# Charlotte Department of Transportation

## Memorandum

**Subject:** Rezoning Petition 08-075: Located on the north side of East Woodlawn Road between Park Road and Halstead Drive  
*(revised 10/14/08)*

PROJECT NO. FFD-06020
 FILENAME: FFD06020-R21
 DESIGNED BY: CSS
 DRAWN BY: CSS
 SCALE: 1" = 40'
 DATE: 10-14-2008
 SHEET NO. **TD-1**

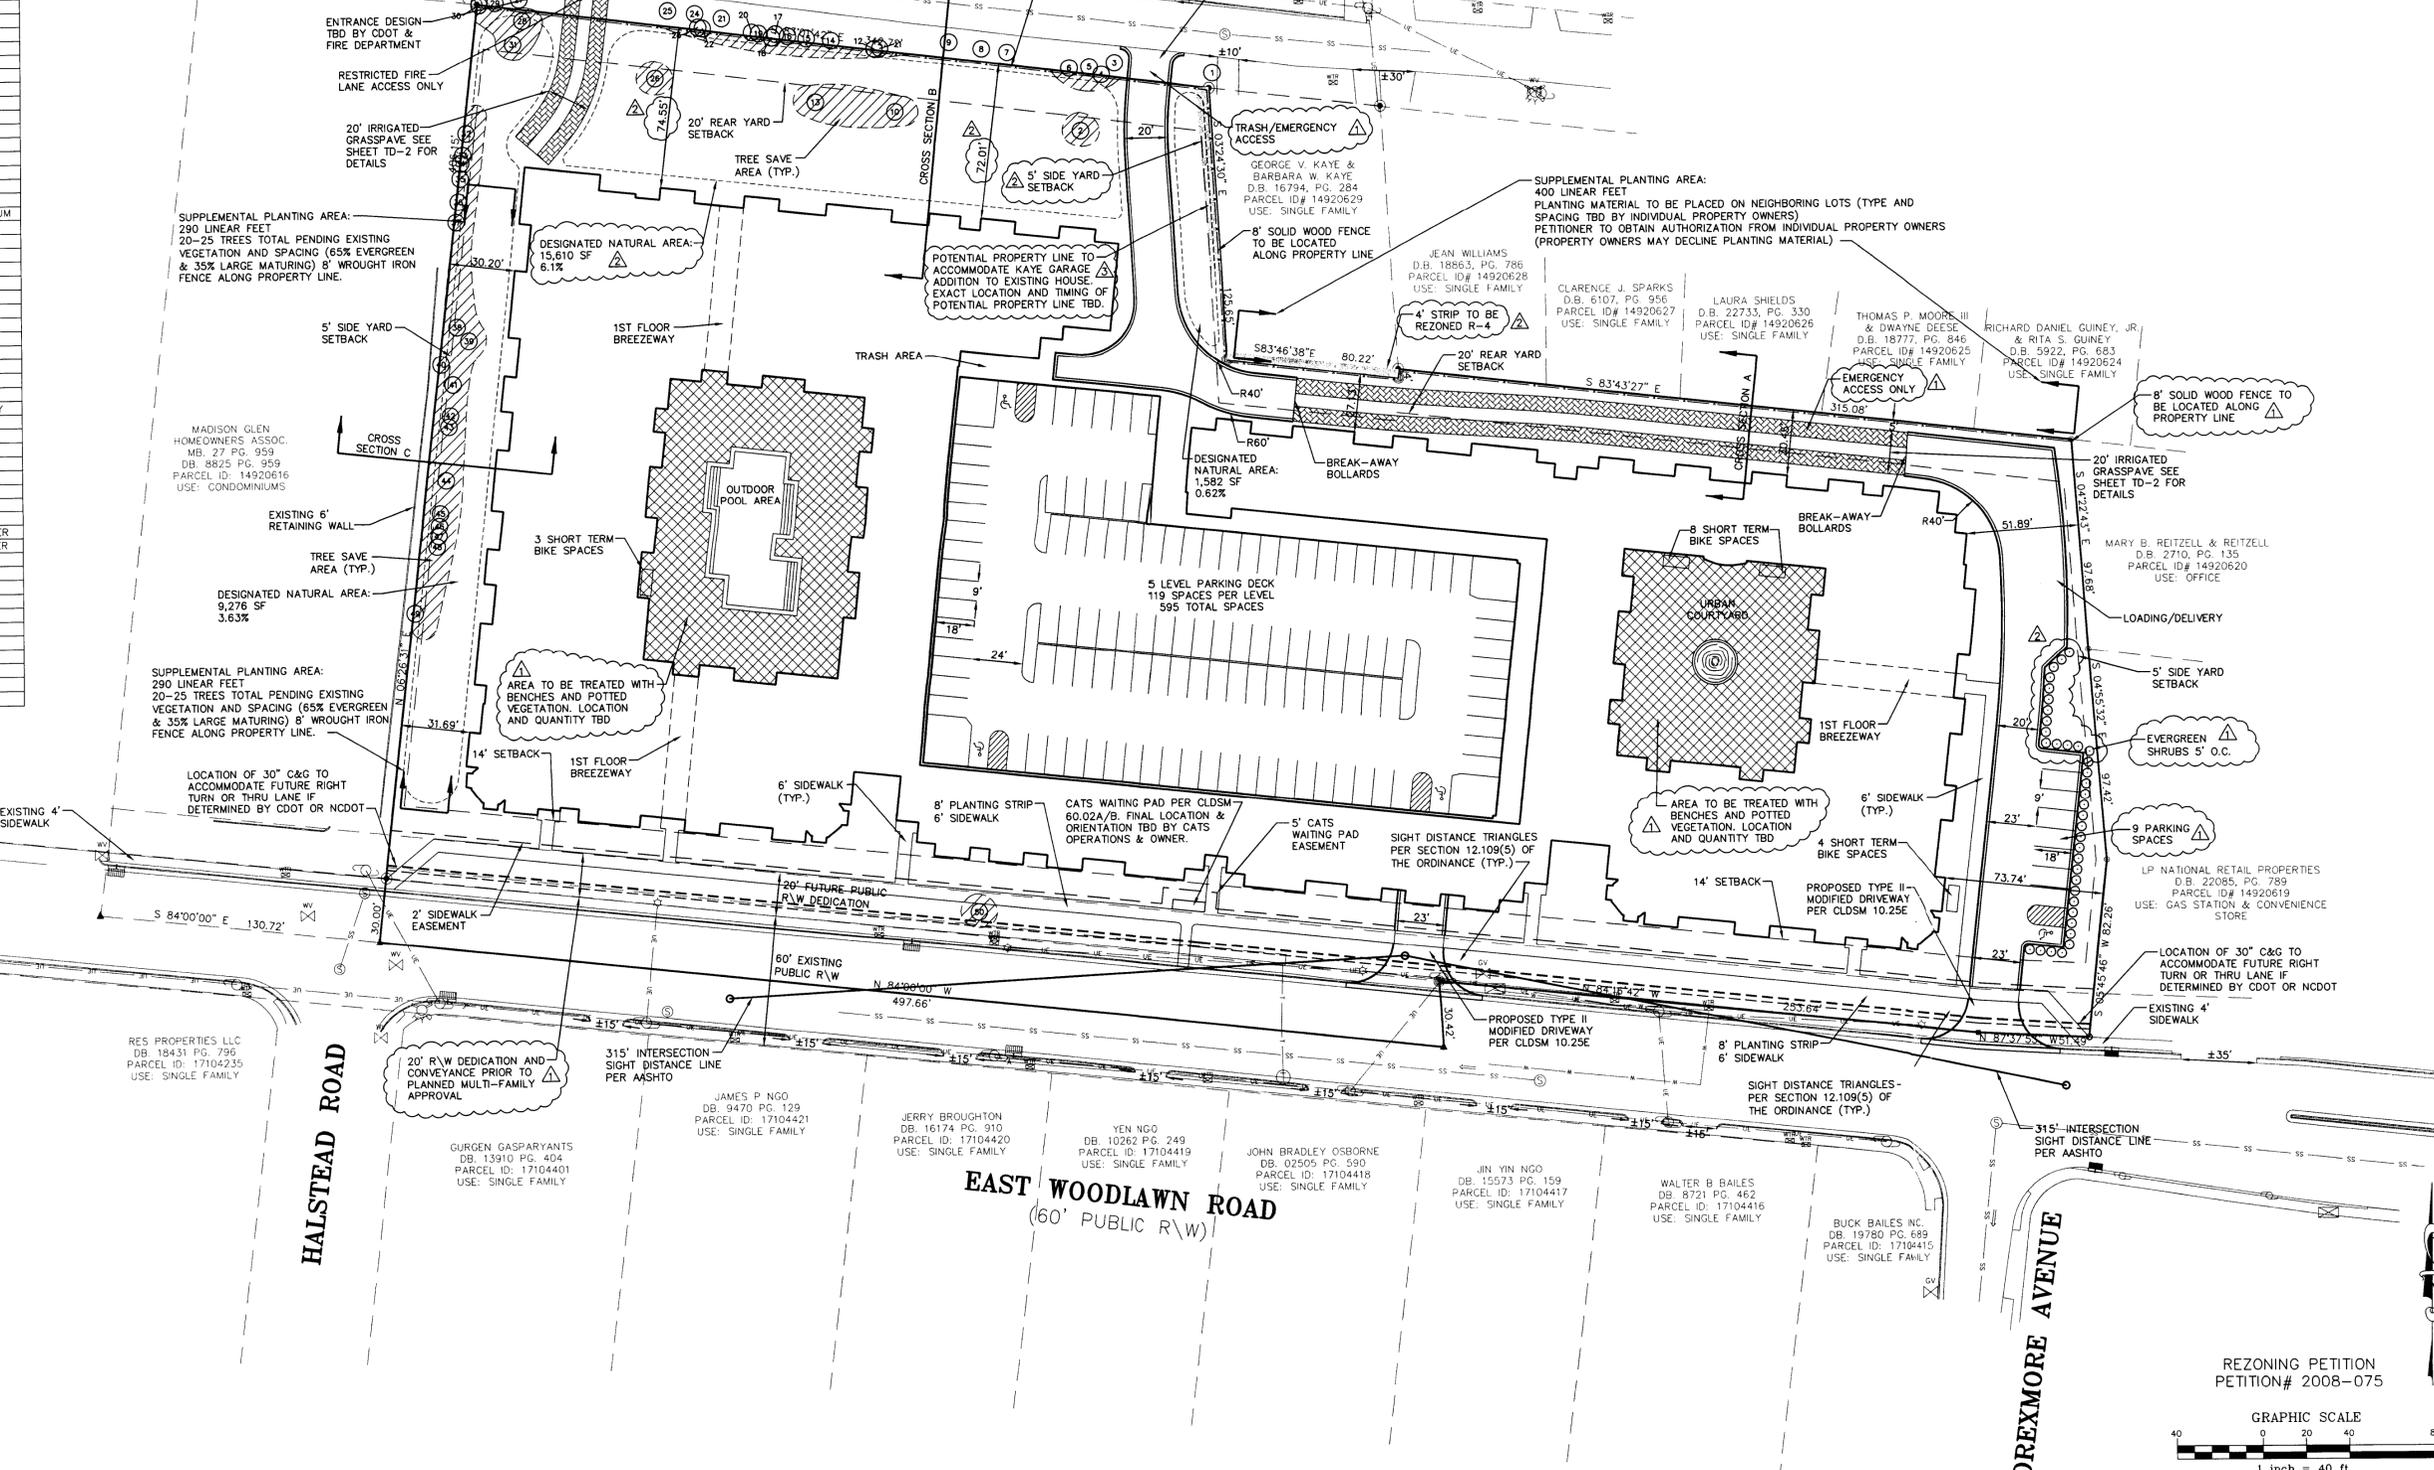
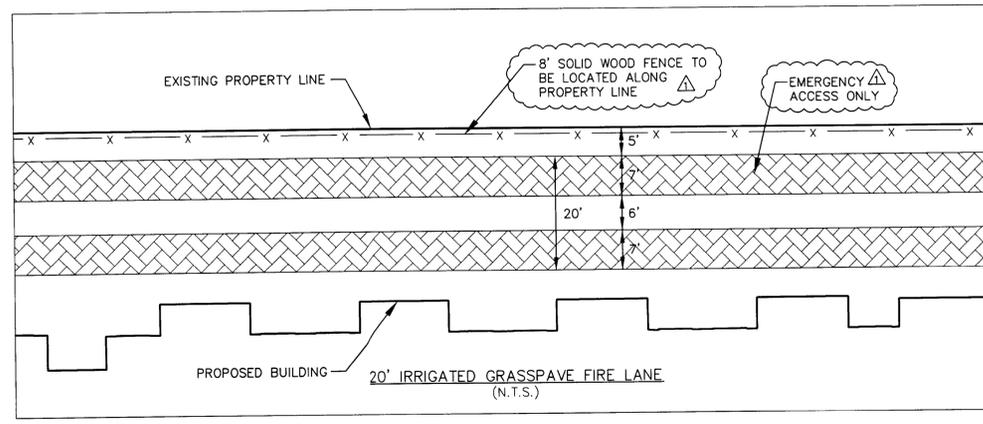
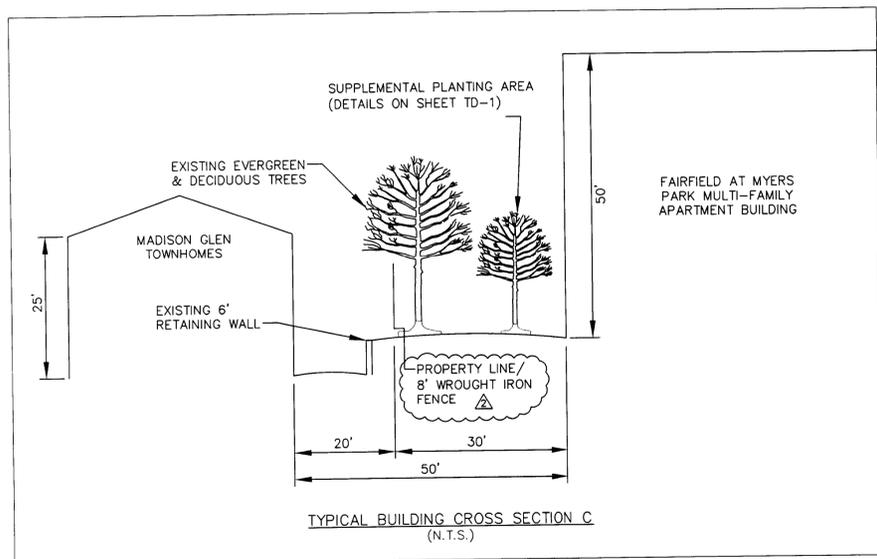
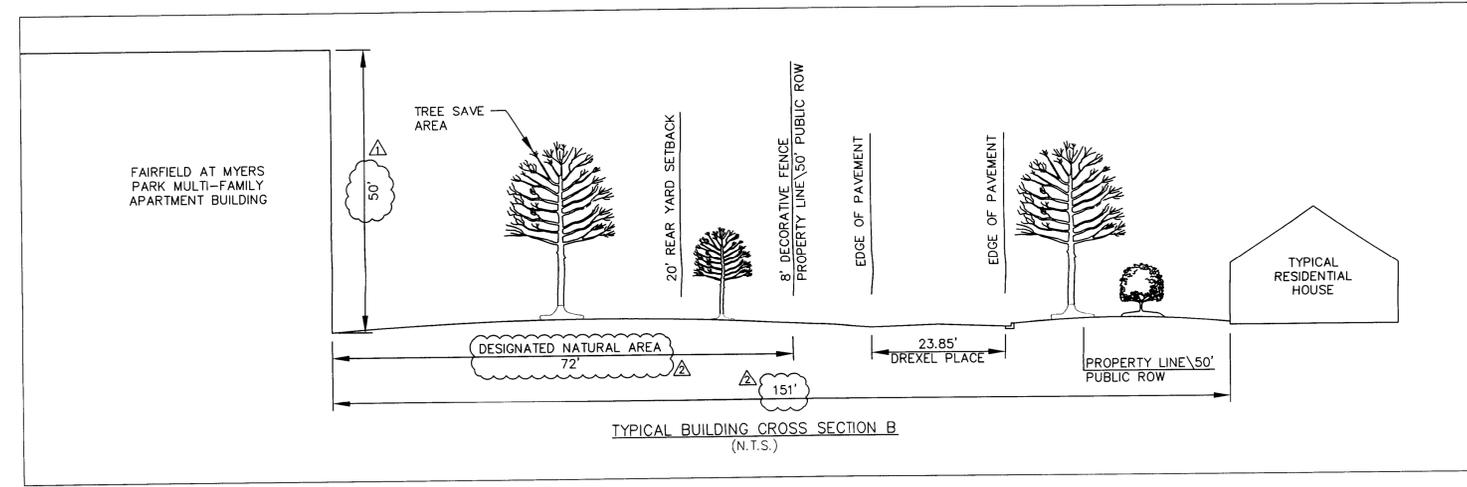
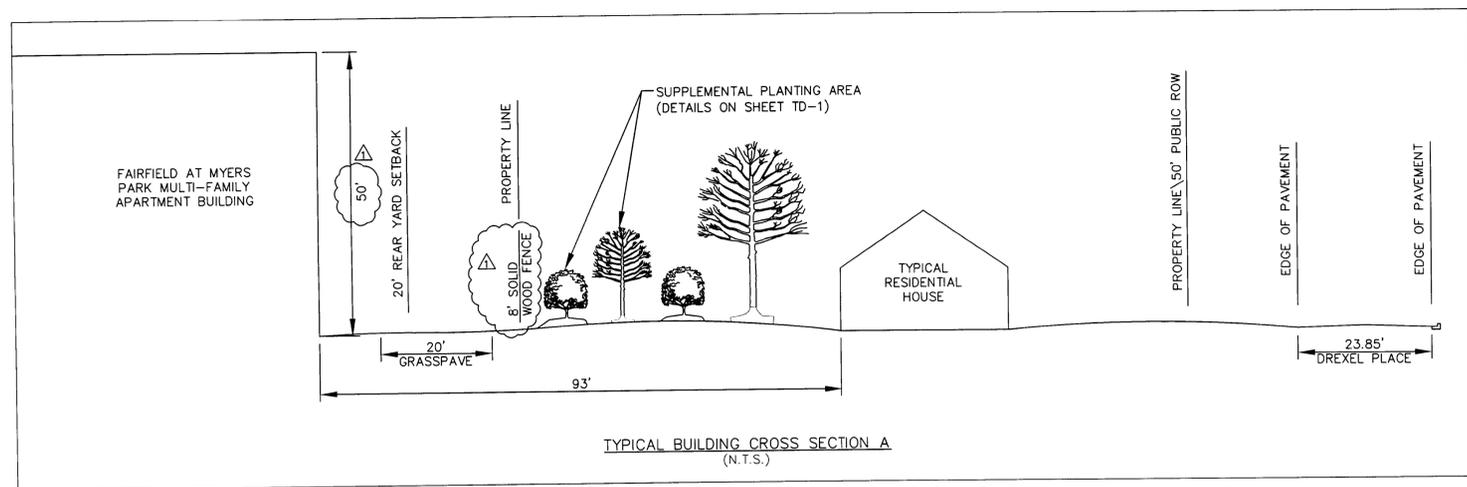
1. The subject site is located in a Center. The preferred block length in a Center is 500 feet and a maximum block length of 650 feet. The current block length on East Woodlawn Road between Park Road and Waterbury Drive exceeds 1,500 feet. This site has approximately 750 feet of frontage along East Woodlawn Road. Both existing and new developments need to be connected by streets, bikeways and pedestrian systems to reduce vehicle miles of travel (TAP Policy 2.9.4). For these reasons a new public street is needed in this location between East Woodlawn Road and Drexel Place. The street should be designed and constructed to

the Local Residential Street-Wide (includes on-street parking that can be recessed) cross section in accordance with the adopted Urban Street Design Guidelines (USDG). This cross section includes 10-foot travel lanes, 7-foot parking lanes, 8-foot planting strips, and 6-foot sidewalks. We recommend that the new street have a curvilinear alignment along the center of the property. (*Previous review comment – 2<sup>nd</sup>*)

2. Woodlawn Road is a state maintained street. The NCDOT has recently indicated to CDOT that they will require left-turn lanes and/or a median to serve the site's driveways through the driveway permit process. To accommodate these requirements a 4.5-foot easement is needed in addition to the 20 feet of right-of-way that the petitioner has committed to dedicate.

3. Should a median on Woodlawn Road be required by the NCDOT restricting access to right-in/right-out movements only and the street connection between Woodlawn Road and Drexel Place is not constructed as described above, an alternate access for this development is needed. For this reason the parking deck for this development needs to connect to the gated driveway to Drexel Place to provide access for residents as well as for emergency and service vehicles.

4. New curb/gutter, planting strip (8'), and sidewalk (5') along Drexel Place are required to be constructed by the developer. The sidewalk can meander to preserve/minimize the impact to existing trees and the existing 6-foot tall wood fence, keeping at least 6 feet away from the new curb/gutter. The site plan needs to show all required items. A waiver of these items may be requested through subsequent building permit phases. (*Previous review comment – 2<sup>nd</sup>*)
